The Clyde River Motor Inn

Preferred Project Report

Major Project Application No: MP06_0008

Demolition of existing structures and construction and stratum/strata subdivision of a new mixed use development comprising shop, restaurant, 46 Serviced apartments, 10 permanent residential apartments and parking for 60 vehicles at No. 3 Clyde Street, Batemans Bay.

4. West (Laneway) Elevation scale 1:200

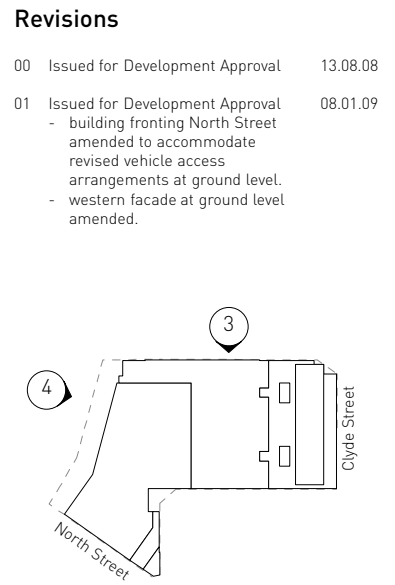
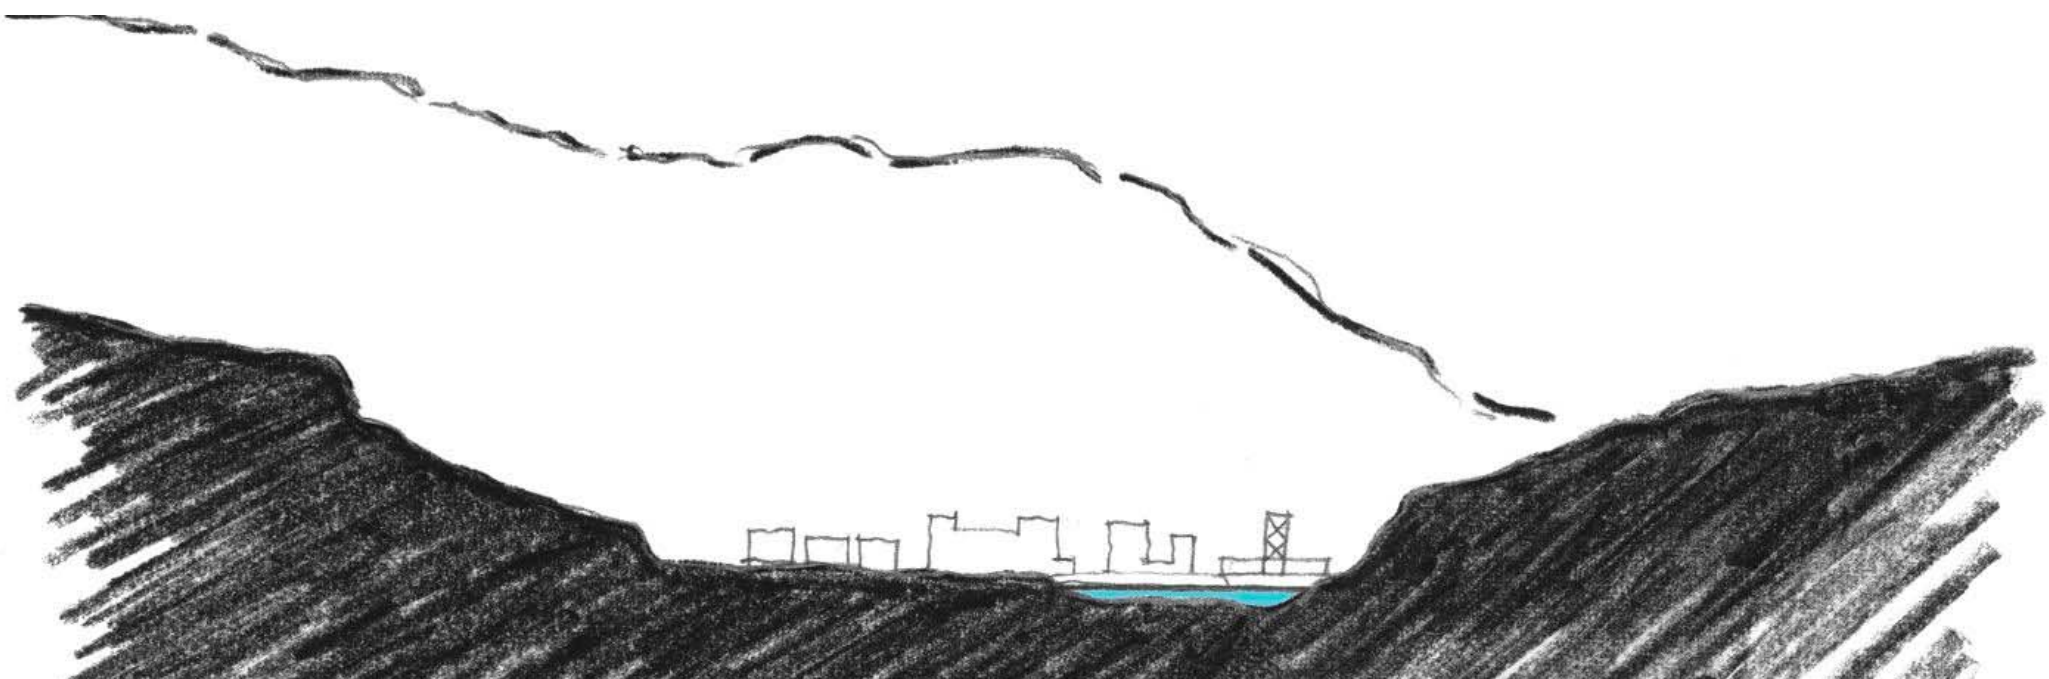
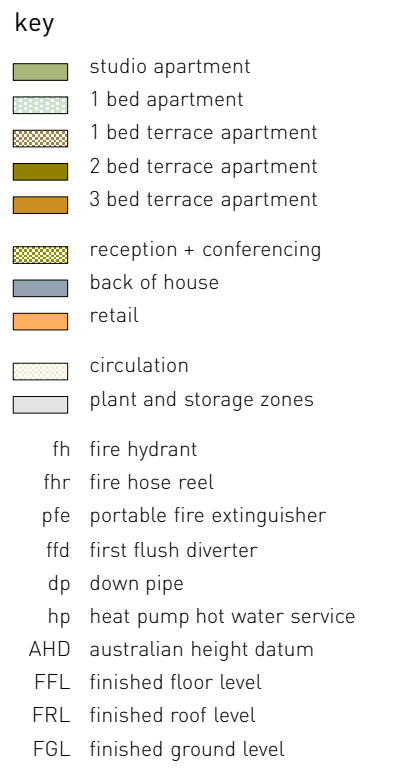
- 2.1.2. *Western elevation – ground level – Address safer-by-design principles by providing greater activation of the ground level elevation to improve passive surveillance and perceived pedestrian and public safety, especially at night; and to avoid the “back lane” appearance. This can be achieved by greater articulation/variety of finishes/pedestrian- level lighting of the “dead” spaces (garbage store, plant and switch rooms).*

Please refer to Appendix C of this report for a revised western elevation (Drawing Number DA03-10 rev 01). The western elevation has been amended to achieve greater articulation/variety of finishes/pedestrian level lighting to the “dead spaces” along this façade.
